Application No: EP/2/21/HH
Site Address: 27A Sea Lane East Preston BN16 1NH
Description of works: Erection of front extension to create first floor balcony, following demolition of existing conservatory with changes to external materials and wall finishes.

Thank you for your internet representation made on 16th February 2021 which has been recorded as an objection with the comments as follows:

Elevations (1:100)

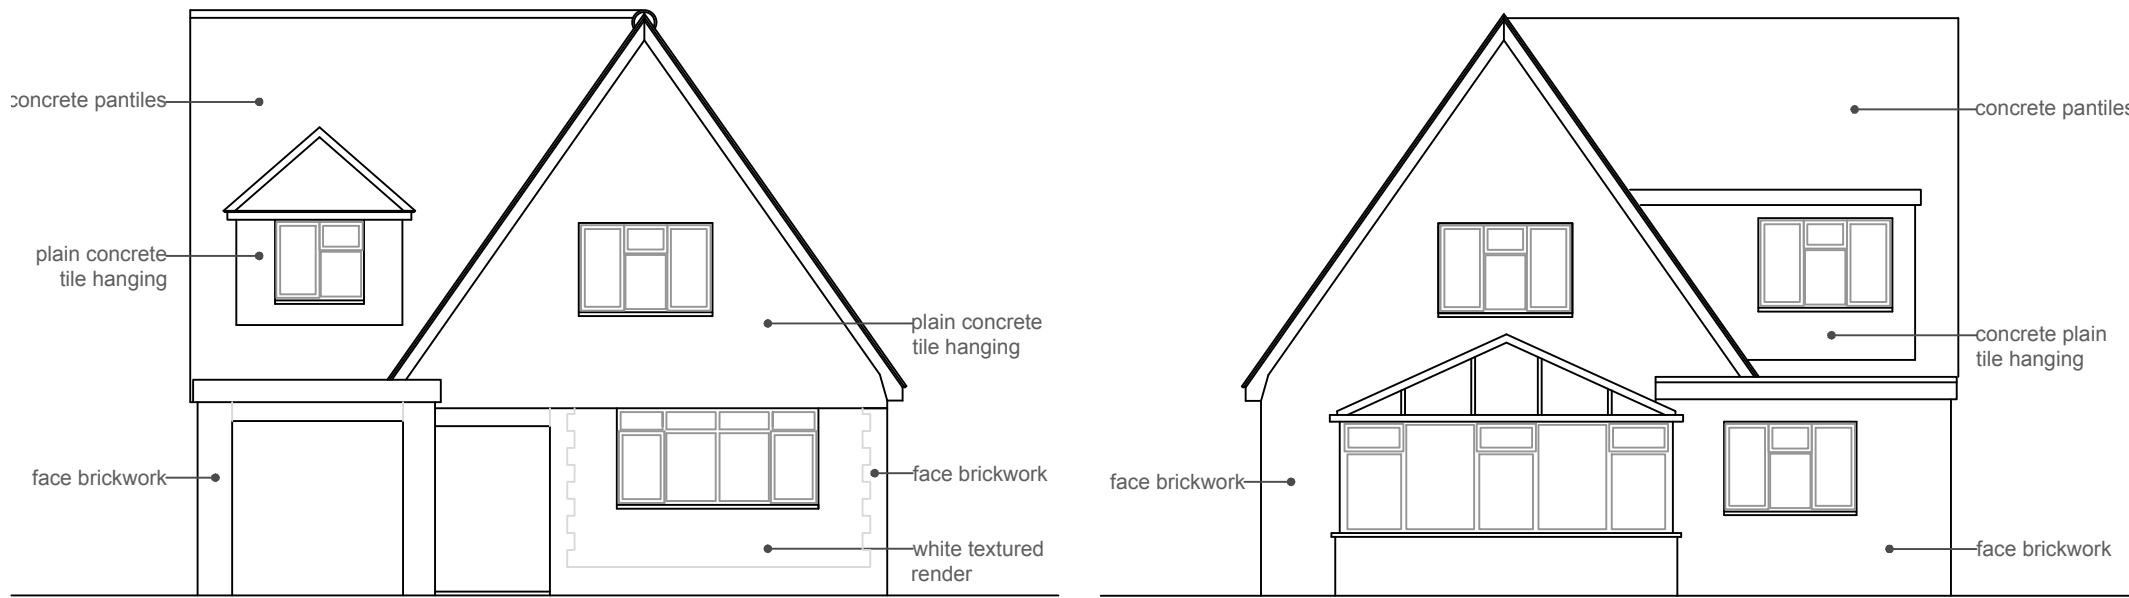
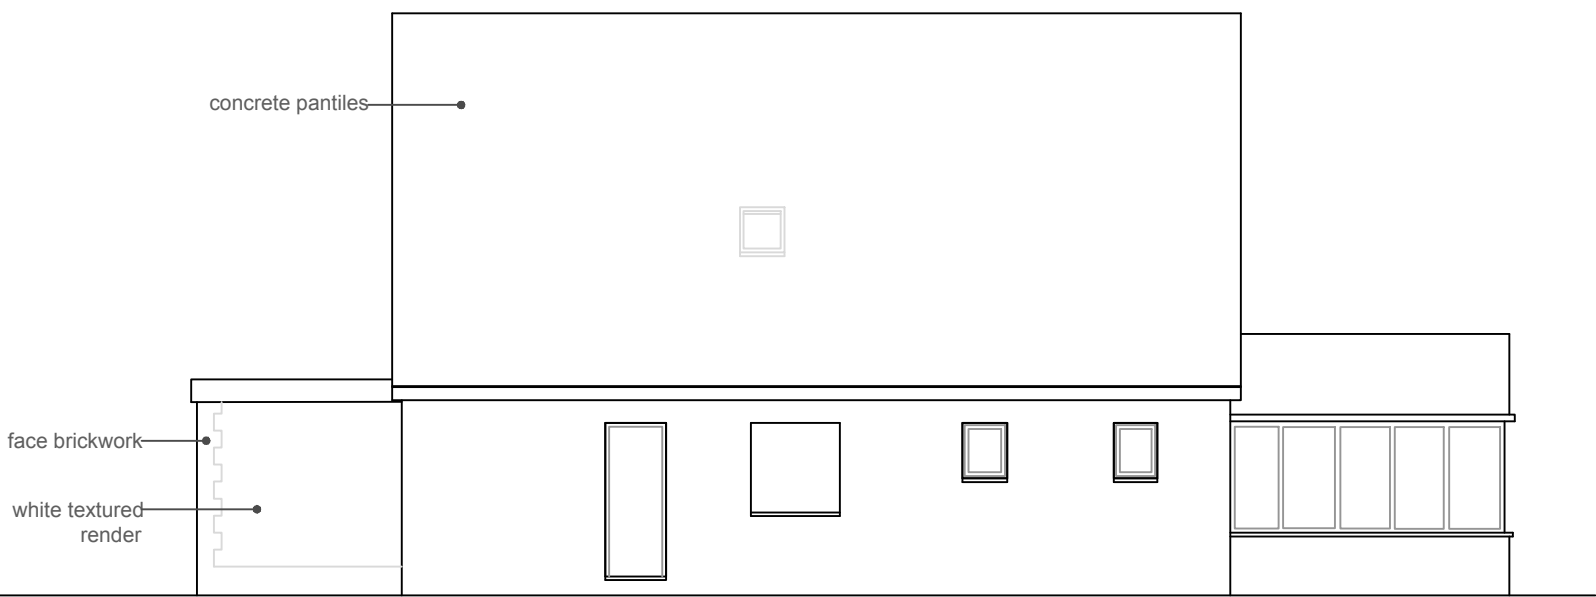
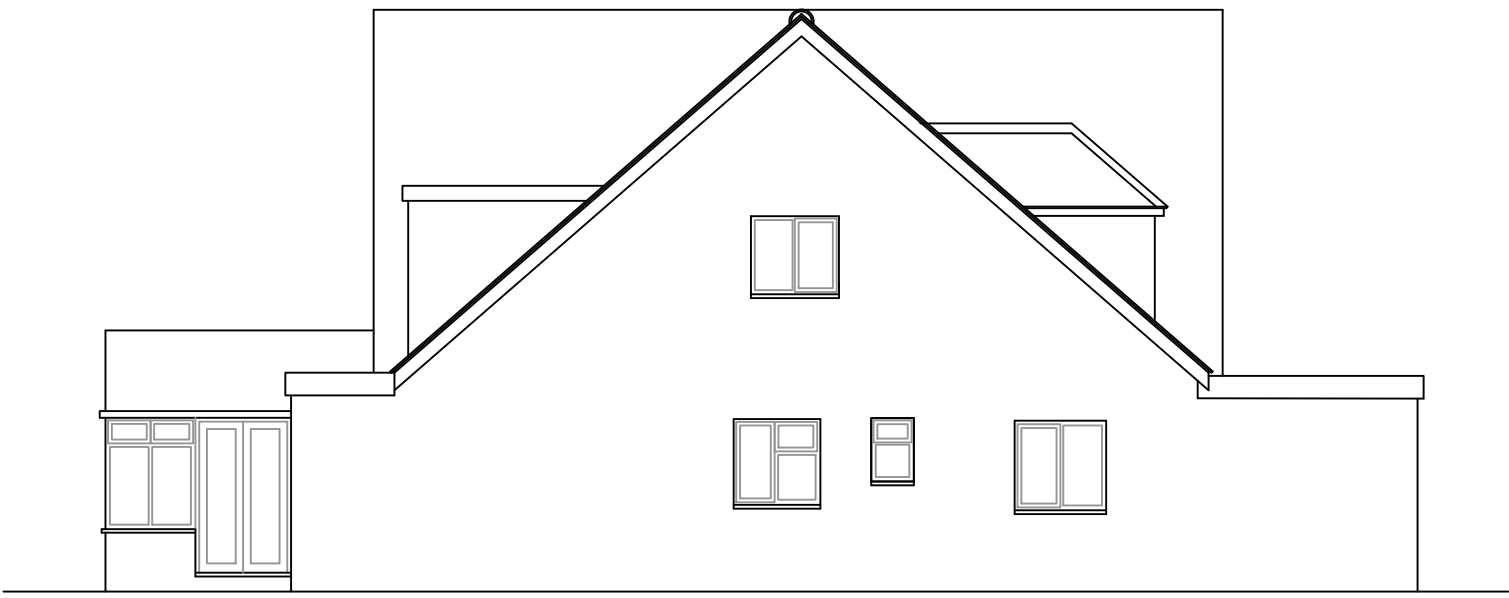
I am writing to object to the proposed planning application for 27a Sea Lane East Preston to build a balcony at the rear of the property which will overlook neighboring gardens invading the privacy held for many years by the residents.

The application itself does not mention the rear of the property, yet the plans clearly show said balcony. Surely this needs planning permission also?

The balcony will be clearly visible from from our day room and garden, therefore giving anyone using it clear sight of us enjoying our garden and indeed into our home if our bifold doors were open.
